OFFICIAL NOTICE OF DECISION

CITY OF ALBUQUERQUE
PLANNING DEPARTMENT
DEVELOPMENT REVIEW BOARD

9. Project # 1003778

LARRY READ & ASSOCIATES INC agent(s) for ADIL RIZVI request(s) the above action(s) for all or a portion of Lot(s) 21 & 22, Block(s) 2, Tract(s) 2, NORTH ALBUQUERQUE ACRES, UNIT 3, (to be known as **SHAHEEN SUBDIVISION**) zoned R-D, located on OAKLAND AVE NE, between WYOMING BLVD NE and LOUISIANA BLVD NE containing approximately 2 acre(s). *[Deferred from 12/8/04, 12/15/04 & 12/29/04] (C-19)*

**PURPOSE OF PLAT:**

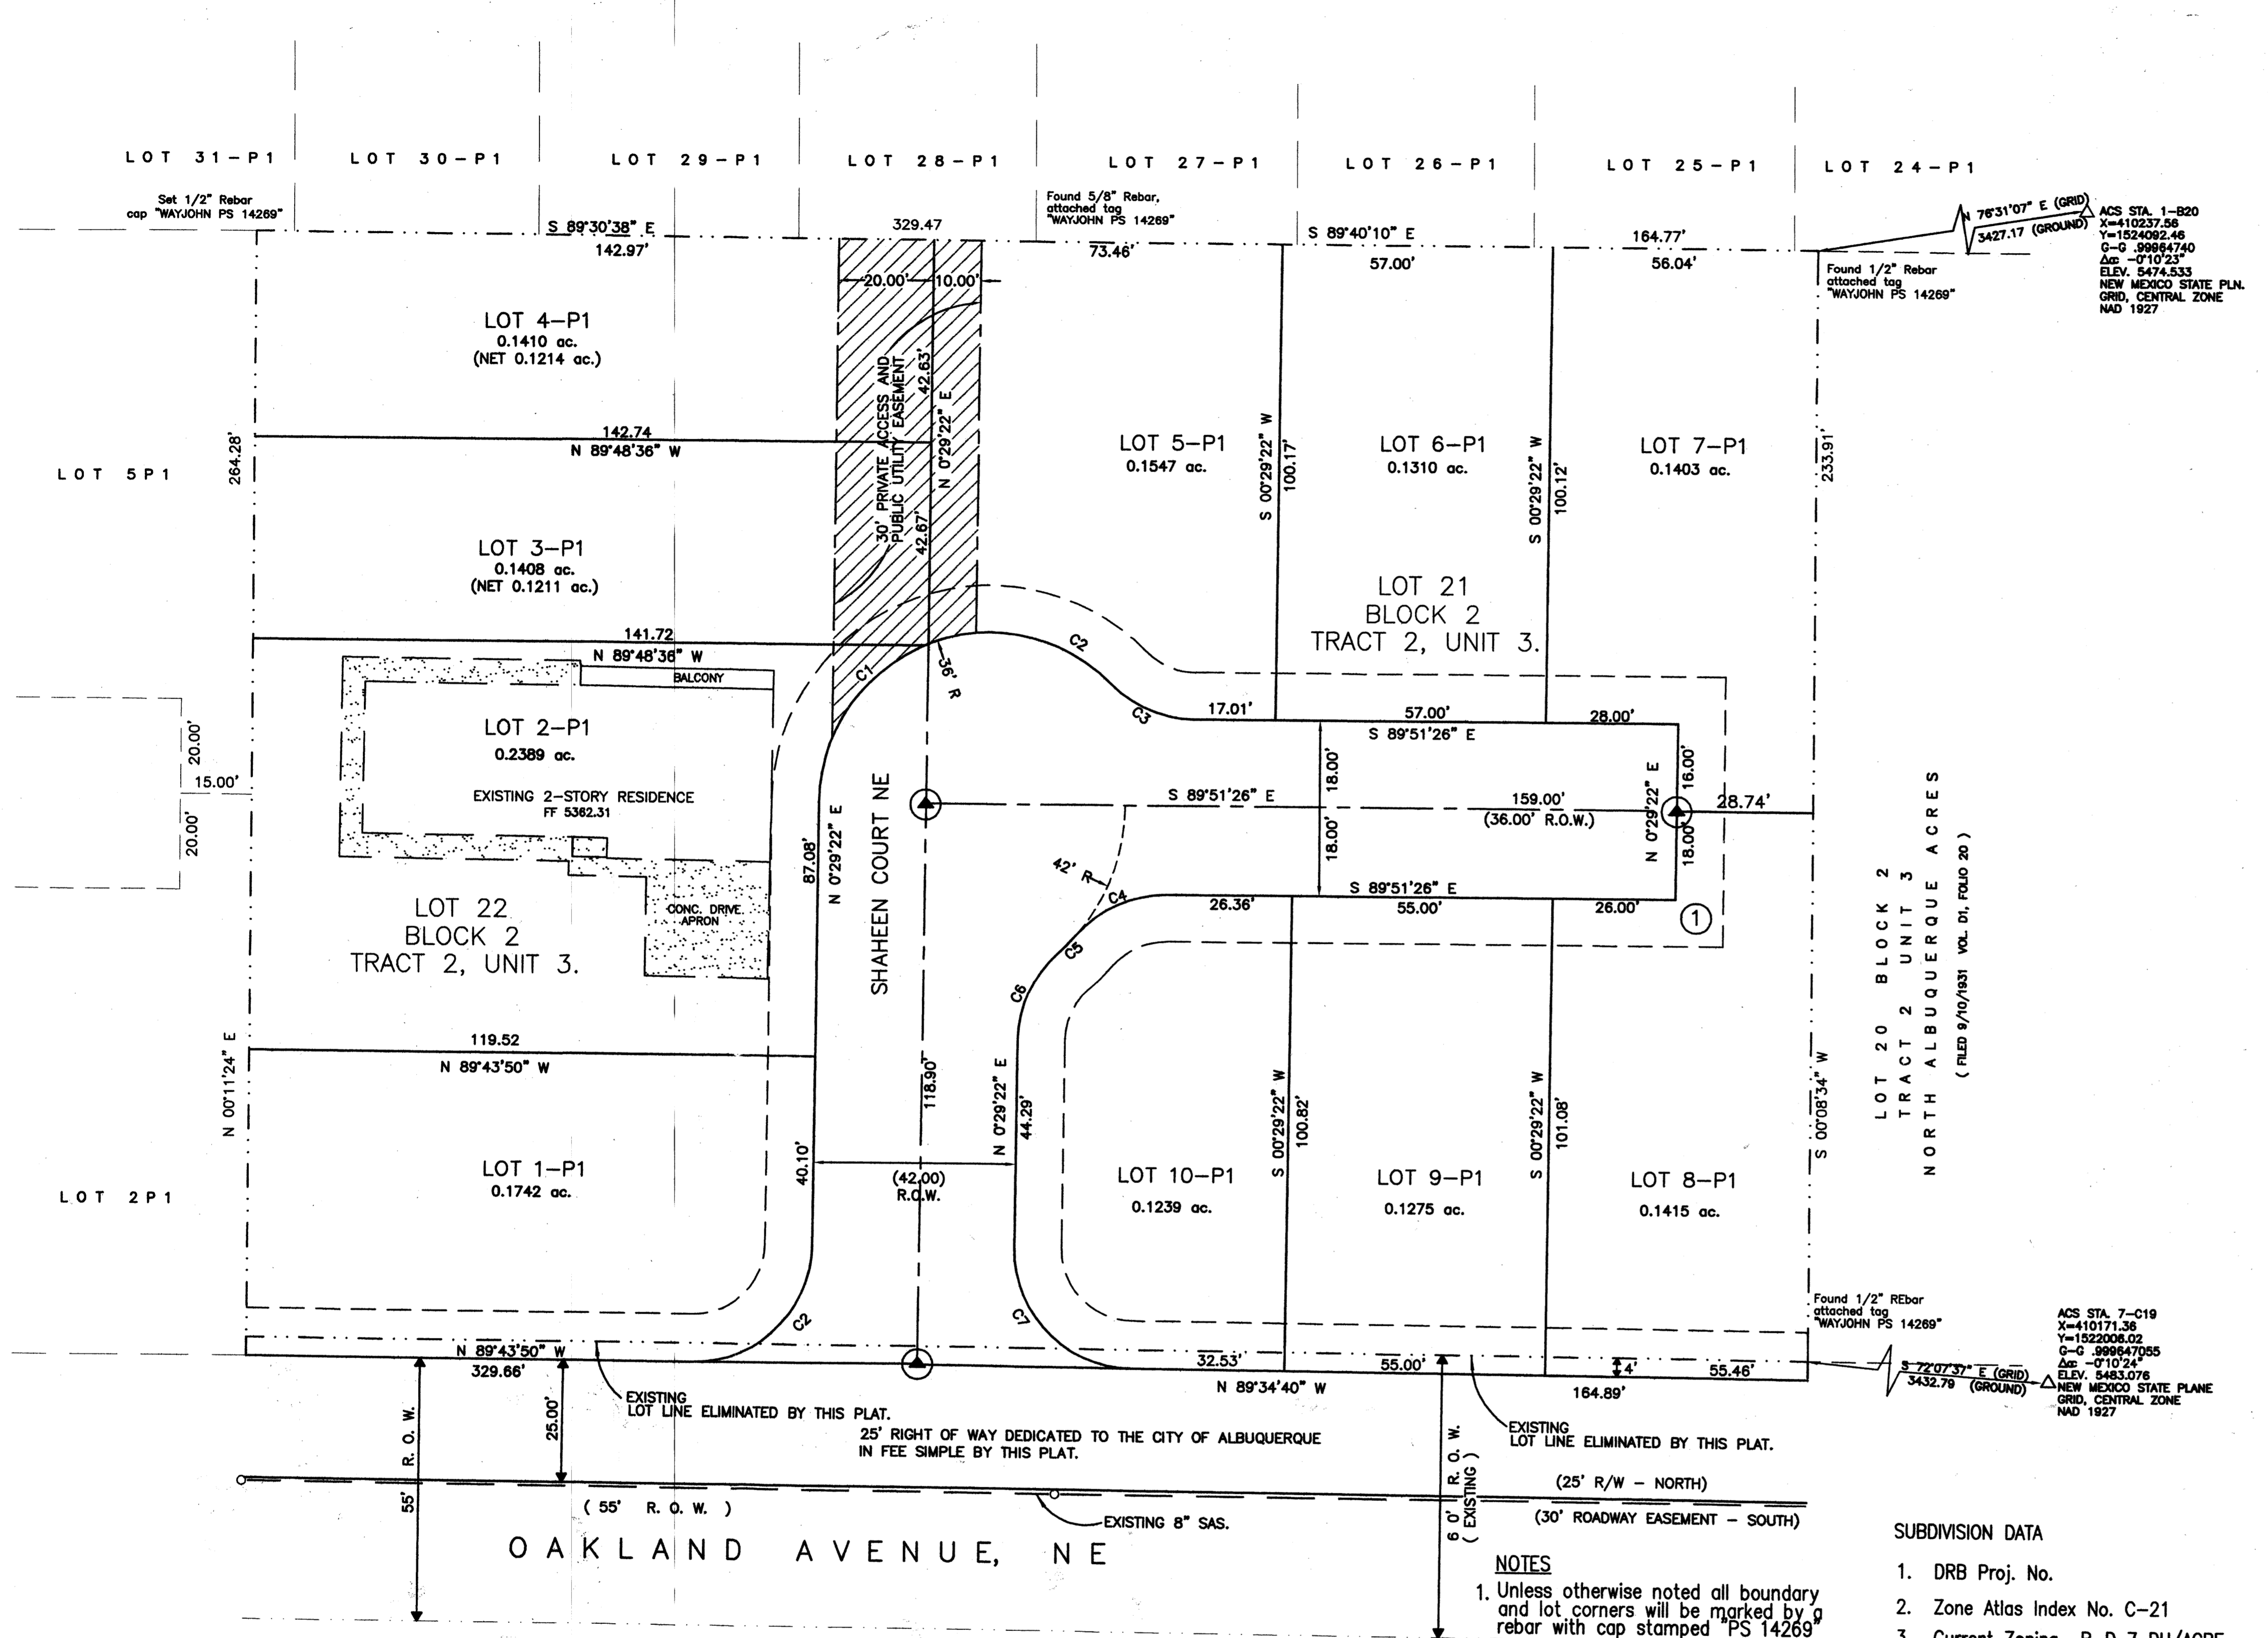
The final plat shall reflect the maintenance and beneficiary of the easement that was granted.

**TITLE:** SHAHEEN SUBDIVISION GRADING AND DRAINAGE PLAN

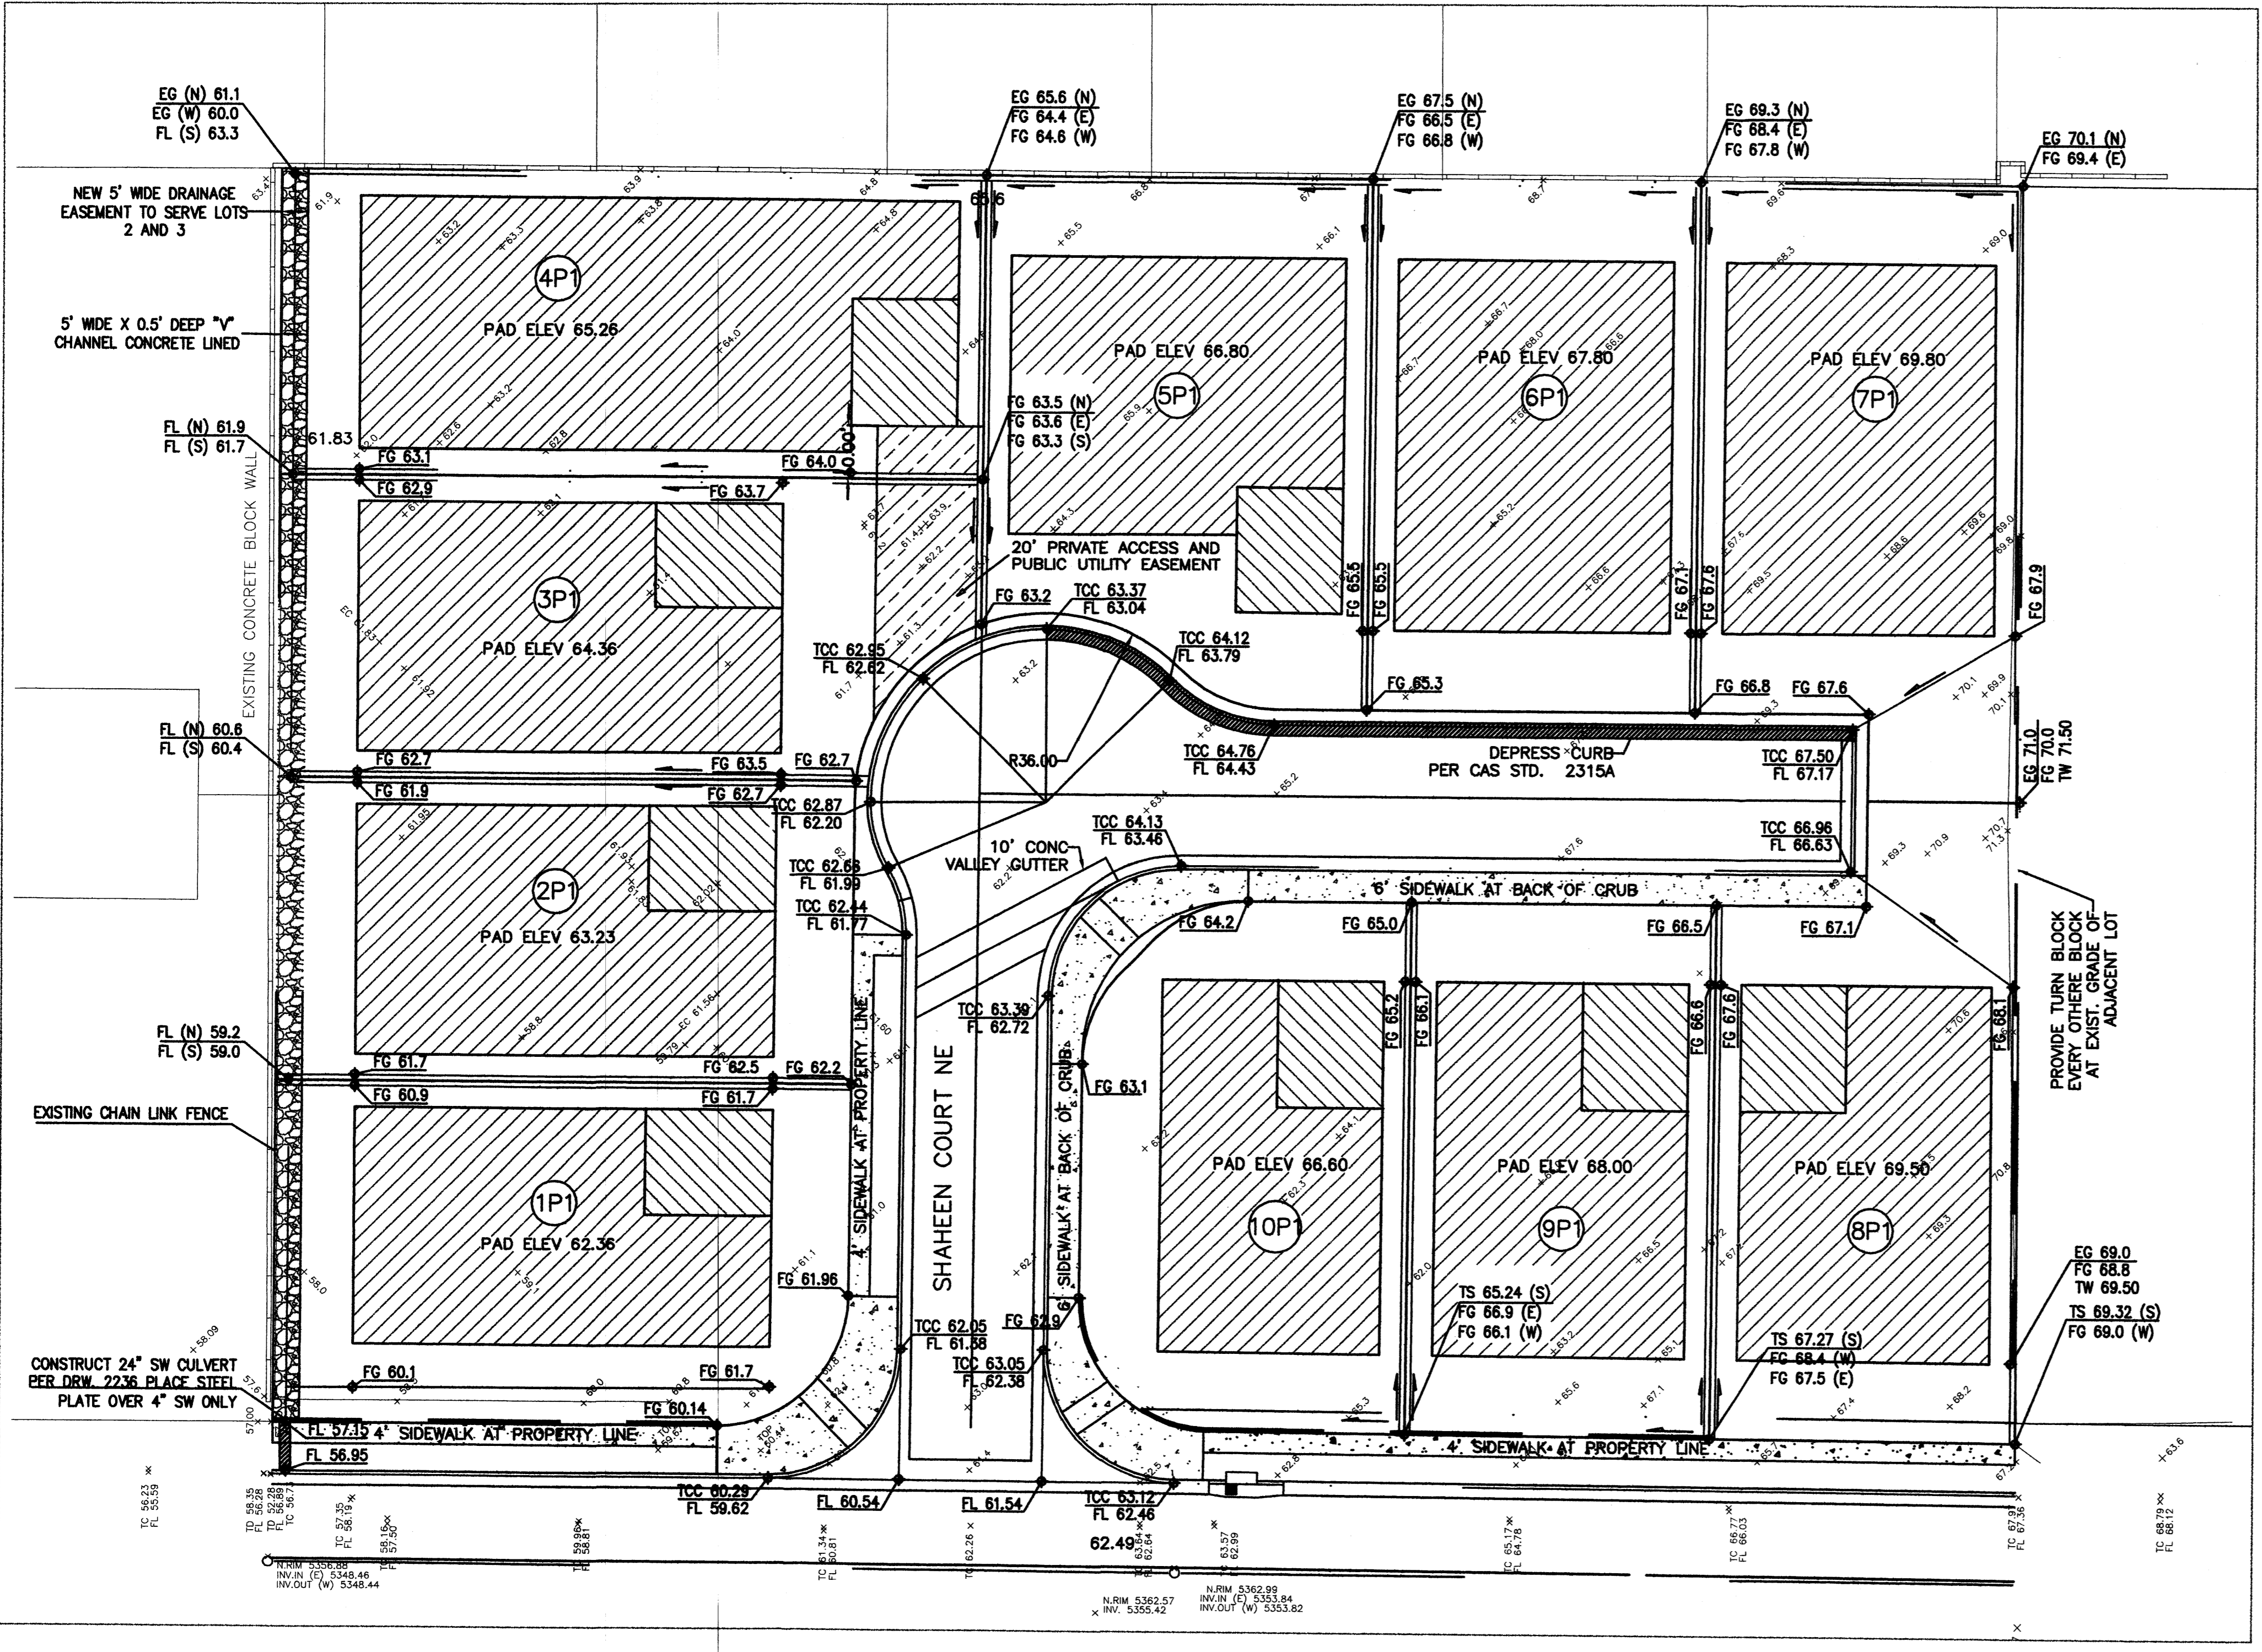
The grading plan shall be revised for minor change to match plat.

At the May 11, 2005, Development Review Board meeting, with the signing of the amended infrastructure list dated 5/11/05 and approval of the amended grading plan engineer stamp dated 3/1/05 the amended preliminary plat was approved.
